Please ask for: Mrs D Johnson
Email: daun.johnson@arun.gov.uk
Telephone: 01903 737762
Our Ref: K/51/21/PL
Your Ref:
Date: 8th November 2021

Application for Planning Permission

Development: Erection of 1 No detached dwelling and integral garage. This site is in CIL Zone 4 and is CIL Liable as new dwelling.
Location: 47 Golden Avenue East Preston BN16 1QX

Drawing Title:
Side Elevations

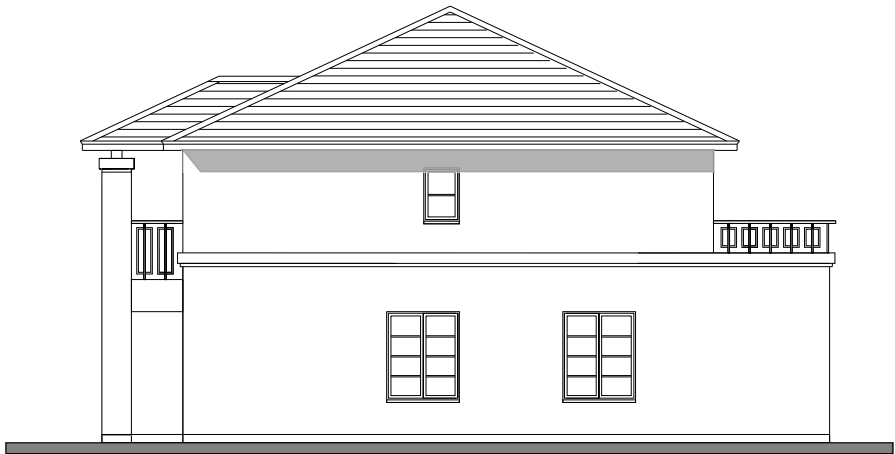
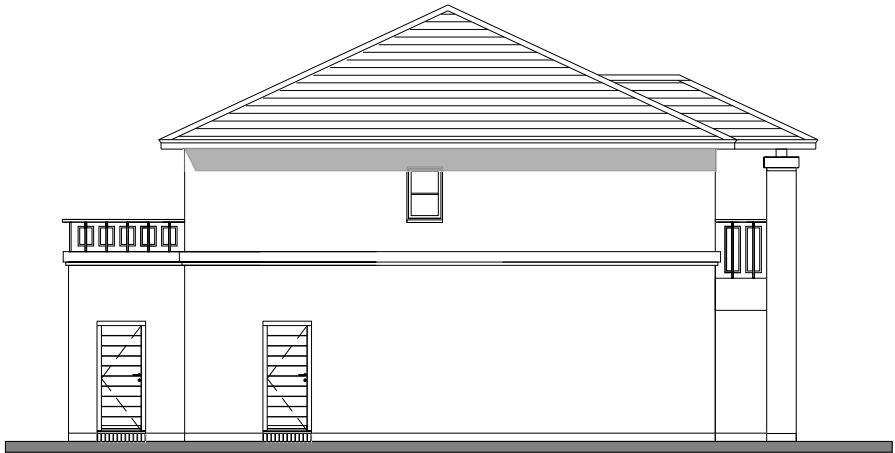
The ground floor plan and side elevation do not accord. Please amend accordingly.
